ANNEX A - SURREY COUNTY COUNCIL - **WRITTEN REPRESENTATION NOVEMBER 2019**

M25 JUNCTION 10/A3 WISLEY INTERCHANGE

PINS Reference: - TR010030

Figure 3-1 Layout of south-facing slips at Ockham as proposed by RHS

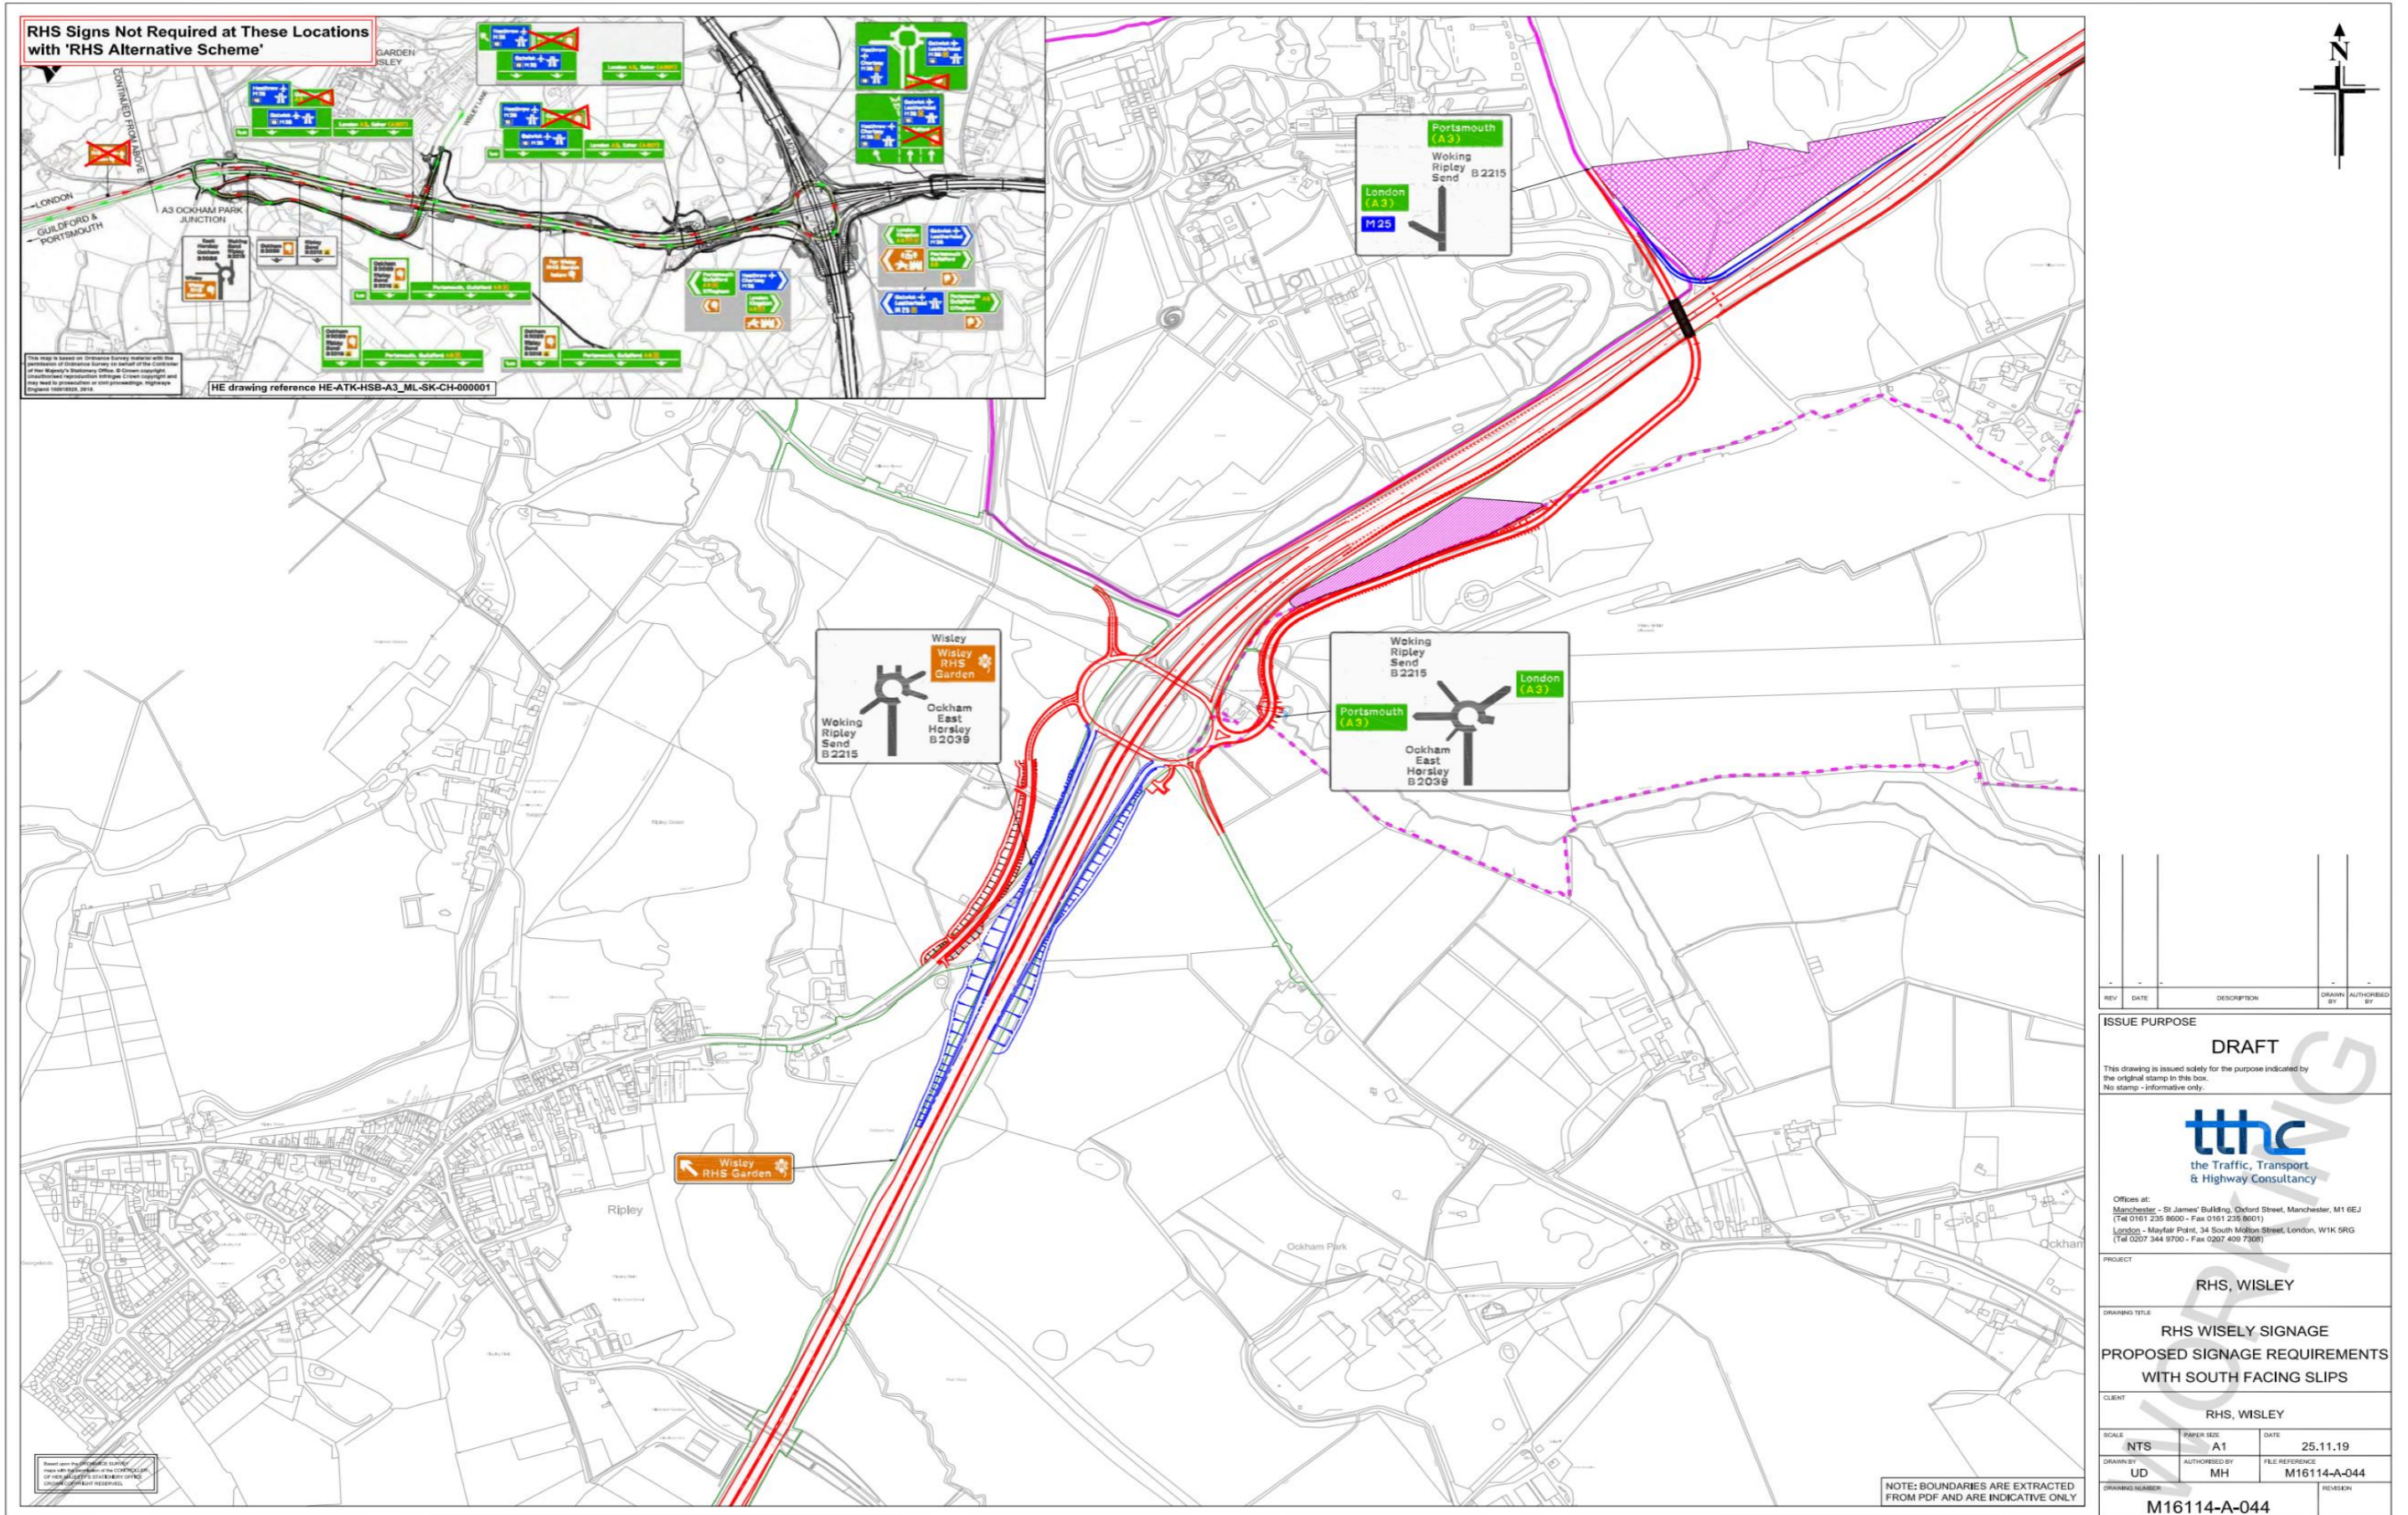
- 2 As set out in para 2.2.5 the County Council would ask that Highways England provide the modelling/evidence in respect of south facing slip roads at the Ockham Roundabout to demonstrate whether these would have a positive impact overall on the Local Road Network and not to the detriment of other communities served by the Local Road Network.

The County Council recognise that this is not currently included in the DCO red line boundary or supporting DCO technical information; the County Council, however wish to understand if both or one of these slips roads e.g. the northbound off slip at Ockham Interchange could provide the required mitigation to the impacts on the Local Road Network including Ripley.
